WEST SUSSEX COUNTY COUNCIL CONSULTATION

TO:	Arun Anita Gardner
FROM:	WSSC - Highways Authority
DATE:	29 March 2022
LOCATION:	Linden Park Recreation Ground Littlehampton BN17 7BS
SUBJECT:	LU/61/22/PL New Fibre Broadband Exchange (Use Class B8 Storage and Distribution). This application is in CIL Zone 4 (Zero Rated) as other development.
DATE OF SITE VISIT:	n/a
RECOMMENDATION:	More Information
S106 CONTRIBUTION TOTAL:	n/a

More Information Request

Drawing Title
PROPOSED SITE PLAN

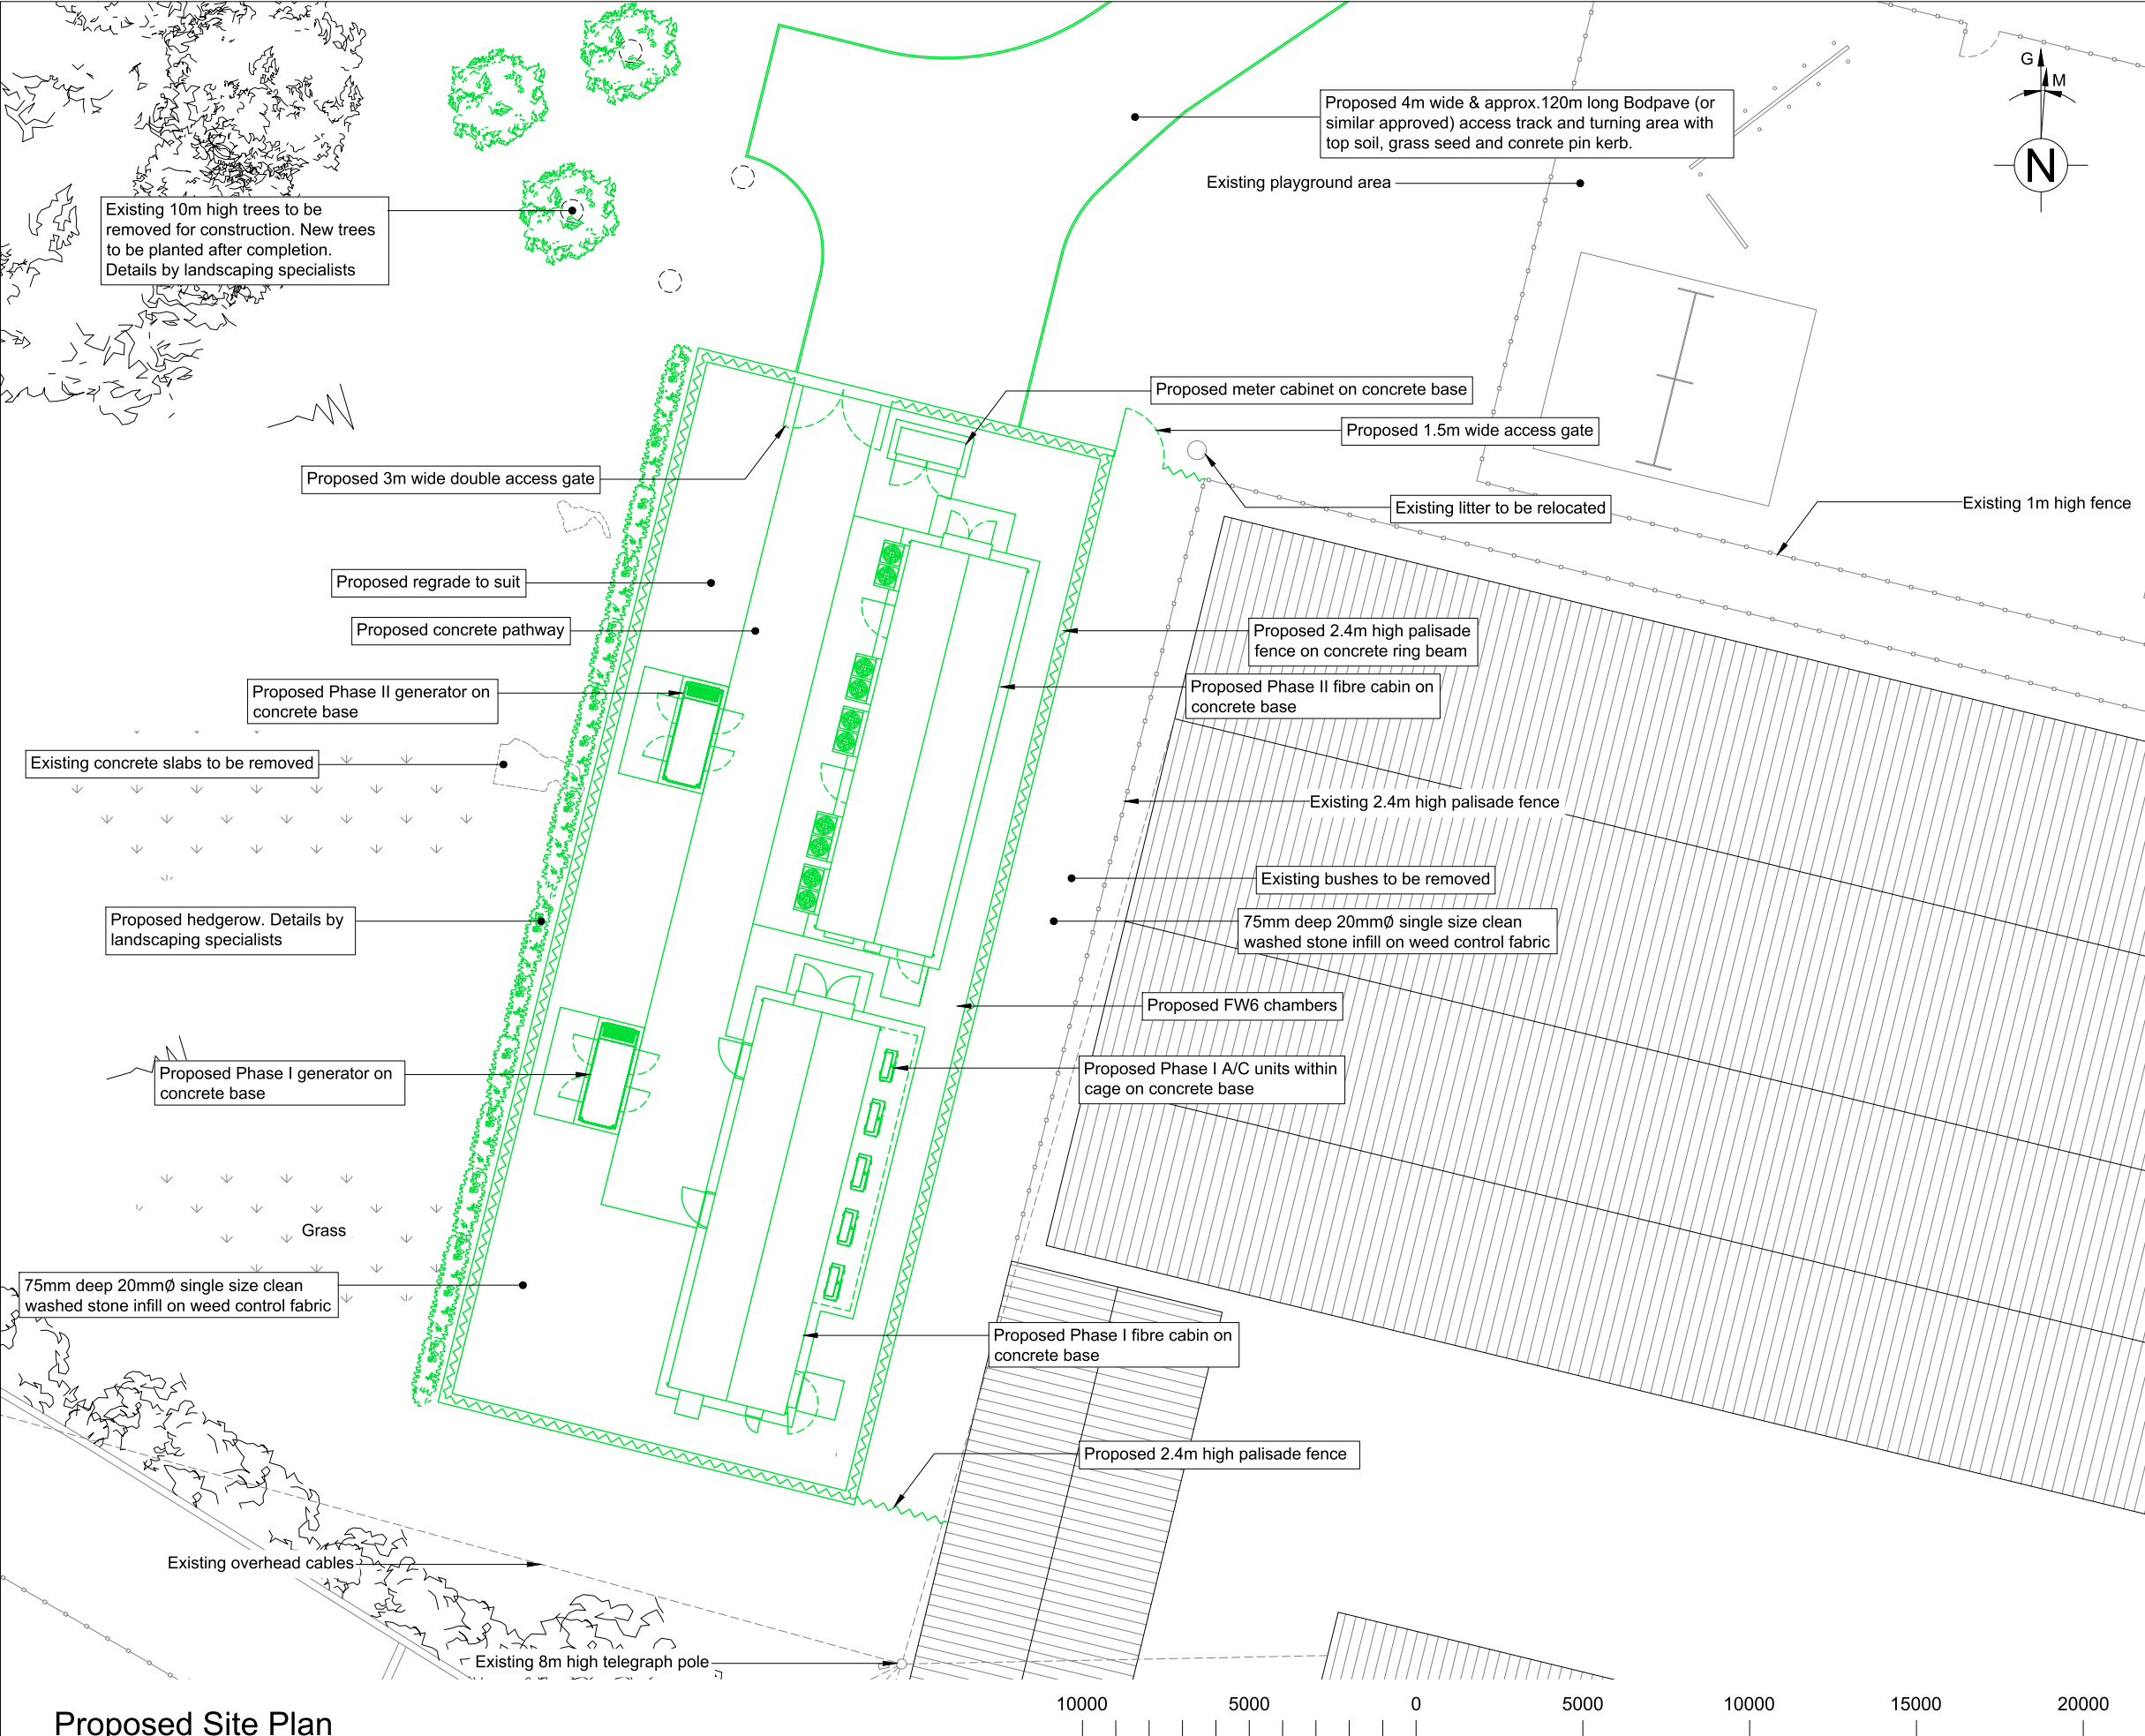
1. Please provide the anticipated trip generation of the site.
2. The applicant states that the site already benefits from a Vehicle Crossover (VCO). The LHA have reasons to believe that this cross over may need formalisation and does not benefit from a license. Please investigate.
3. Please provide a parking provision and justification to Arun's Parking Guidance.
